CITY OF ALBUQUERQUE

**RE: 908 Four Hills Rd SE
Grading & Drainage Plan
Engineer's Stamp Date: not signed
Hydrology File: M23D023
Case # HYDR-2025-00426**

Based upon the information provided in your submittal received 11/30/2025, the Grading & Drainage Plan **is not approved** for Building Permit. The following comments need to be addressed for approval of the above referenced project.

ENGINEER'S SEAL	LOT 1, BLOCK 9, FOUR HILLS VILLAGE, 908 FOUR HILLS ROAD SE	DRAWN BY MM
	GRADING AND DRAINAGE PLAN	DATE 11-28-2025
	 Rio Grande Engineering P.O. BOX 93824 ALBUQUERQUE, NM 87199 (505) 321-8099	SHEET # C1
DAVID SOULE P.E. #14522		JOB #

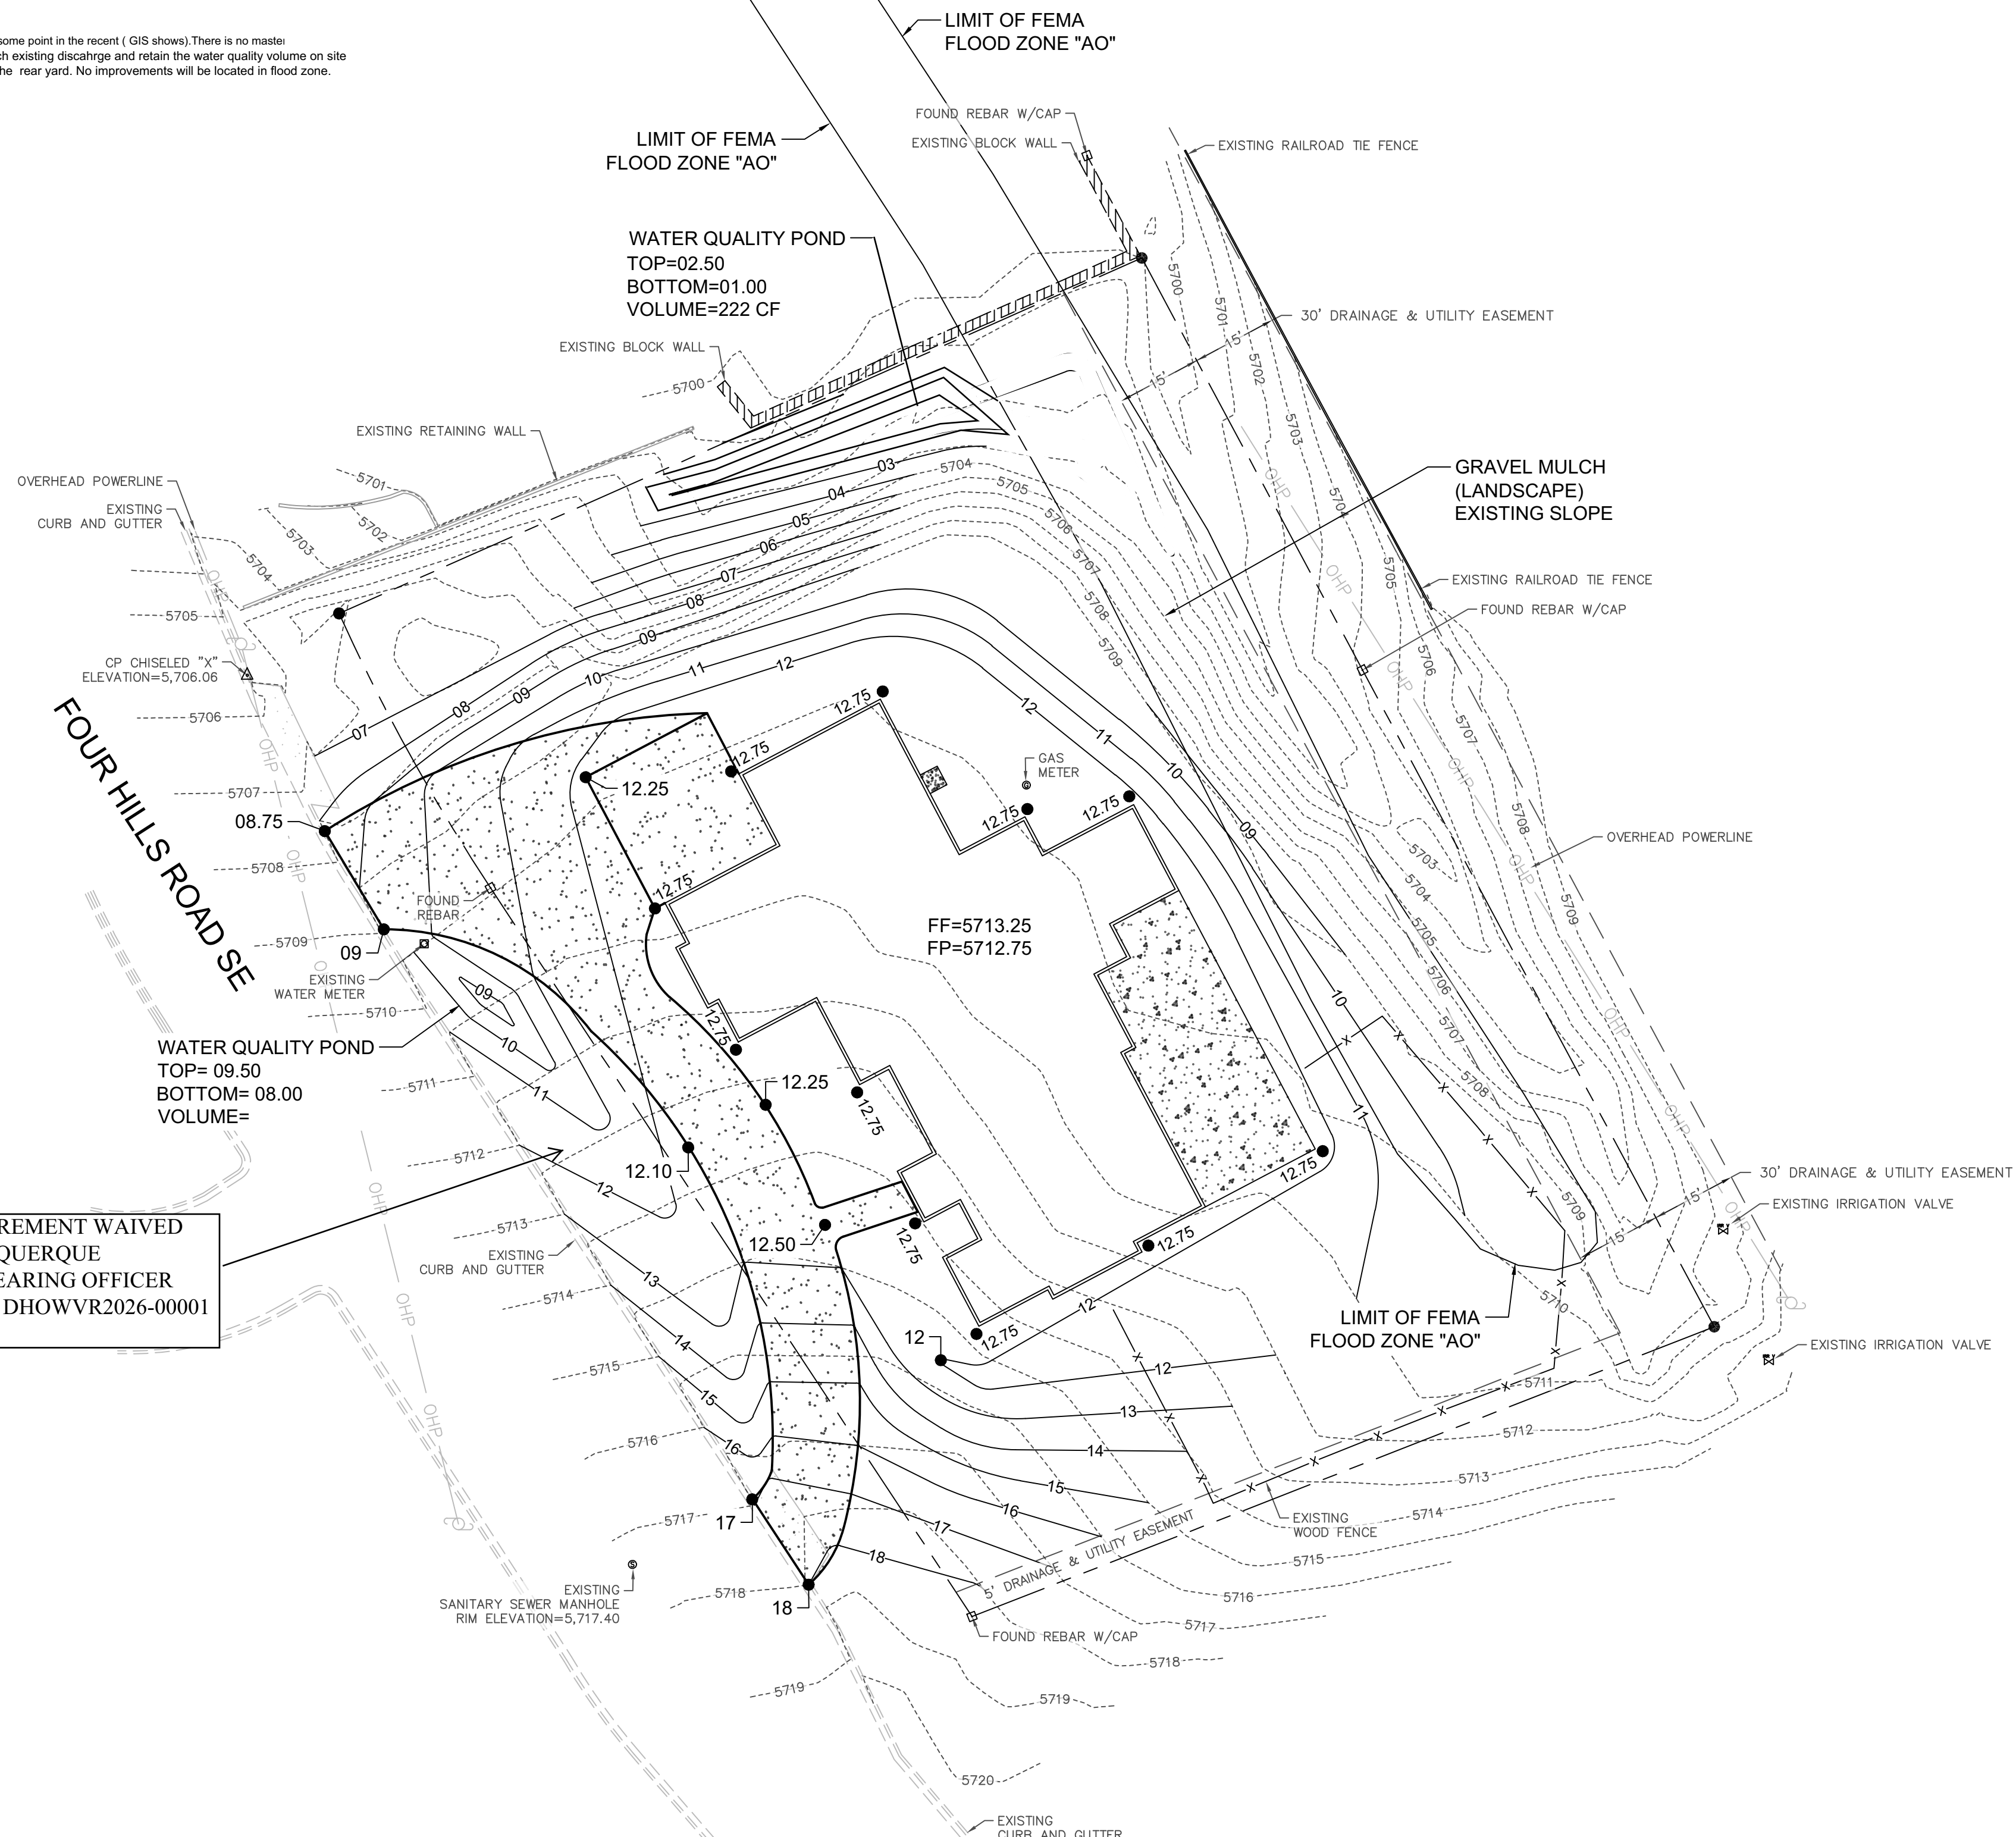
1. Per the IDO, the property owner of the property is responsible for building the adjacent half of Four Hills Road to include curb & gutter, and sidewalk. The project will have to go to the Development Facilitation Team (DFT) for approval of the Infrastructure List.
2. Please show the curb & gutter, and sidewalk on the plans.
3. Please provide an engineer's stamp with a signature and date.
4. Submit a Floodplain Development Permit for approval.
